Subject: Planning application no 2026/62/90232/W New Mills, Brougham Road, Marsden, Huddersfield, HD7 6AZ

These comments are submitted on behalf of the Marsden Blueprint Partnership and Marsden Community Trust. The application is so important and complex that it is not possible to compose comments in adequate detail within the word count limit accommodated on the website, so this email is used instead with a brief summary on the website referring to its submission

BOUNDARY SECTION A

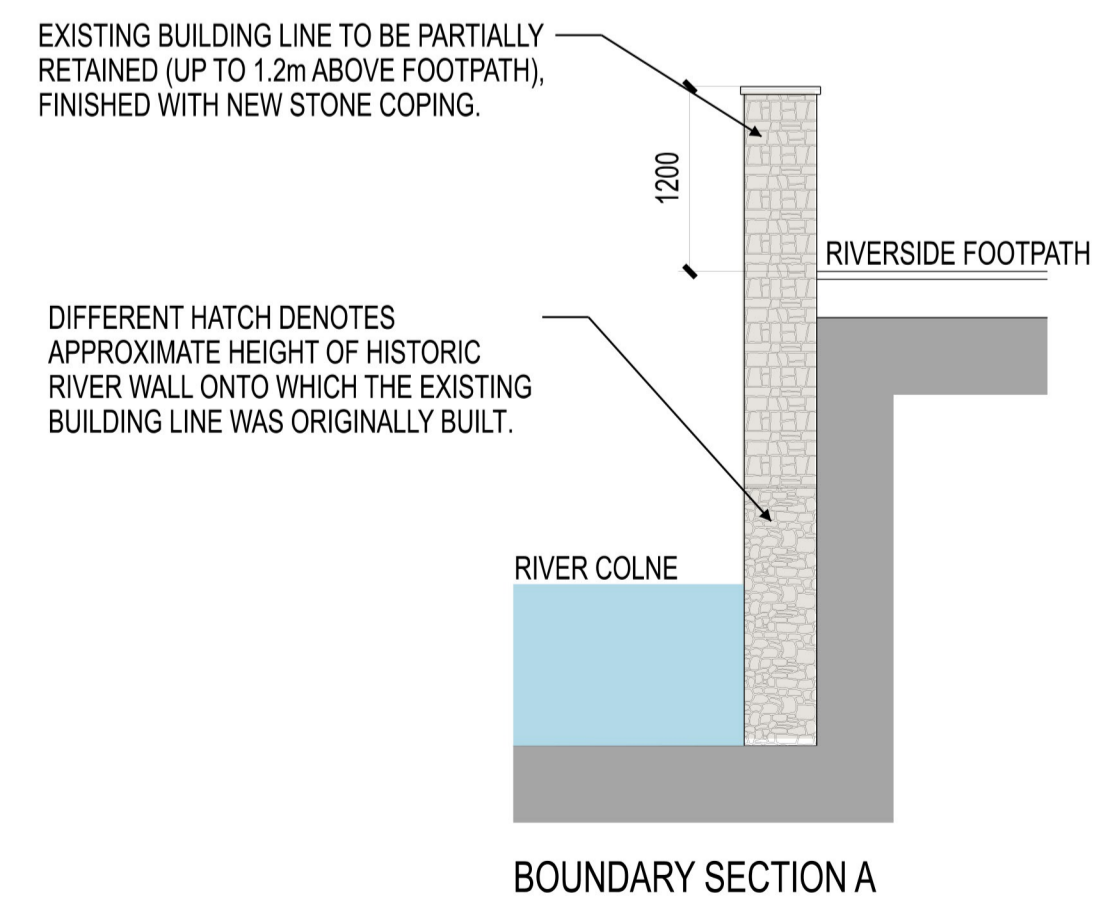
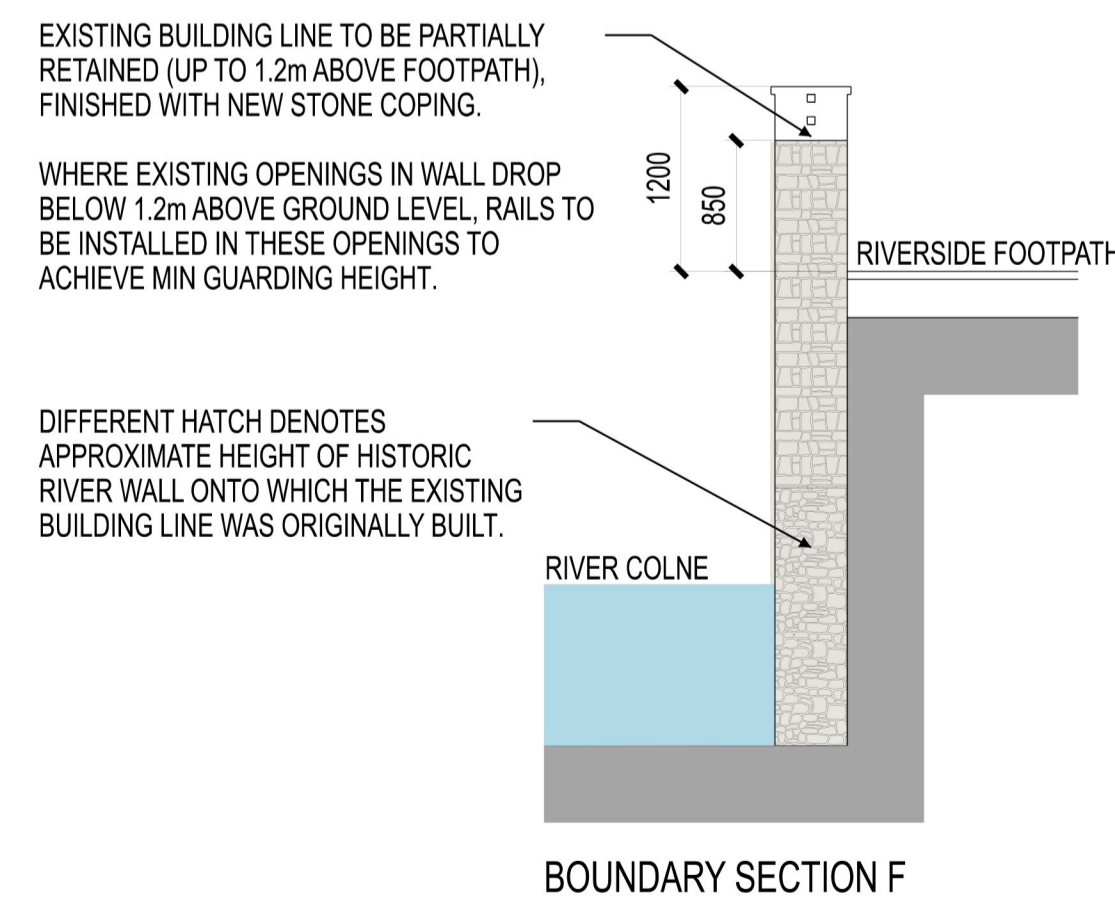
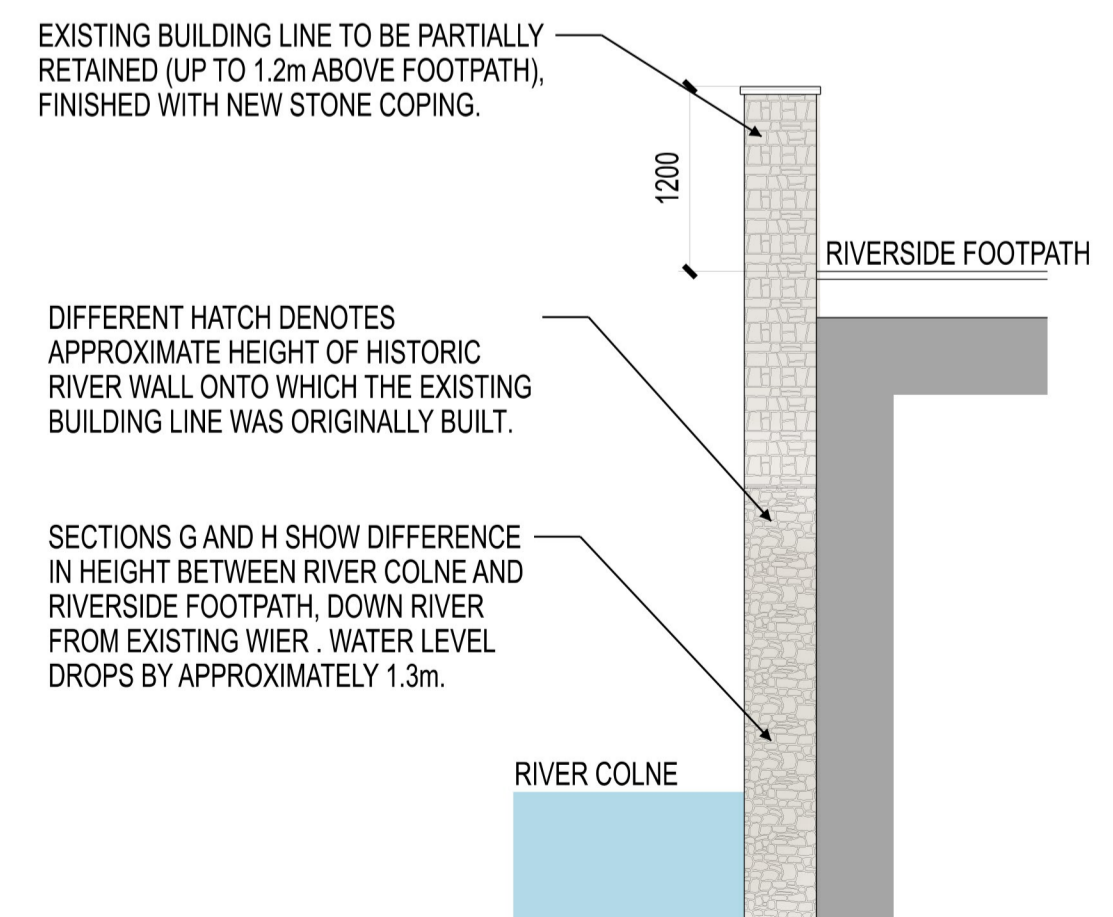
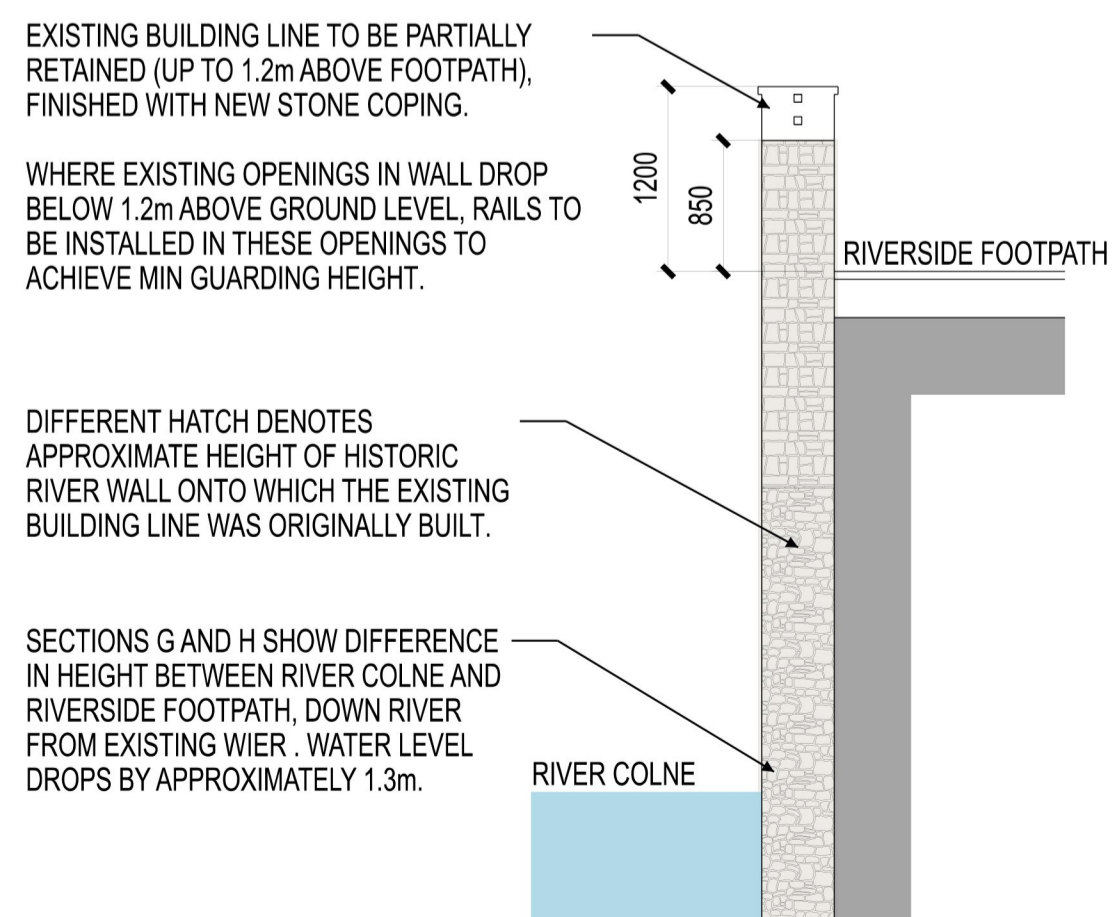
The scale of technical drawings is such that confident appraisal is difficult, whereas the CGIs do little to give comfort because there is an impression of high walls that may limit visibility in and out of the site. That 'fortress' impression is one of the main shortcomings of the existing complex and works against the sort of permeability referred to above. It would be helpful to have conditions imposed that require more detail of visibility to be shown prior to construction. Treatment of the cleared area north of the river channel is of particular interest as this could provide valuable visibility of the river. Railings may be more appropriate than even more stone walls along riversides. Designation of natural green space without access instils fears of it gathering litter and doing little to improve the experience of walking or driving along Crowther Bruce Mill Road.

## Opportunities

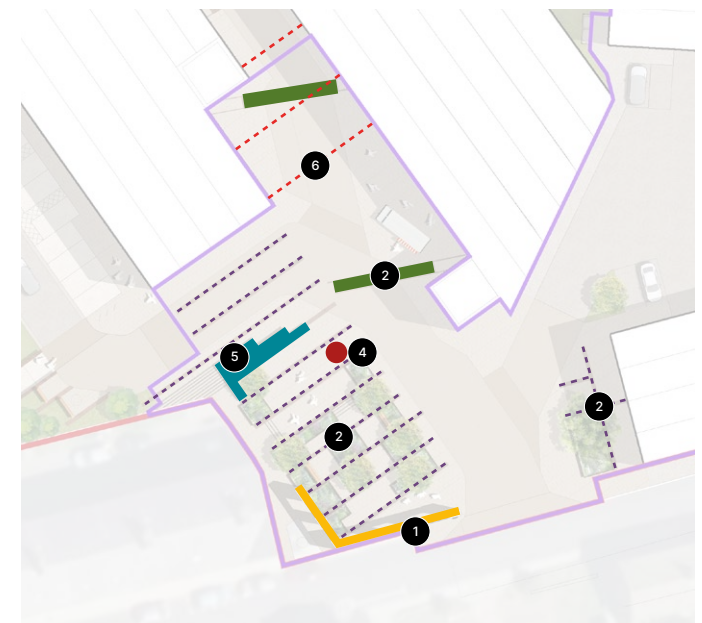
The quality of heritage appraisal is not as thorough as hoped for, leaving gaps in justification for some of the demolition, although the final decisions on retention are generally sound. What remains thin is a dependable record of heritage elements lost and a lucid narrative in the design detail. There are opportunities for this to be remedied within the details yet to come, for instance the new public space could incorporate some rescued artefacts and an interesting narrative of the site's part played in Marsden's textile history.
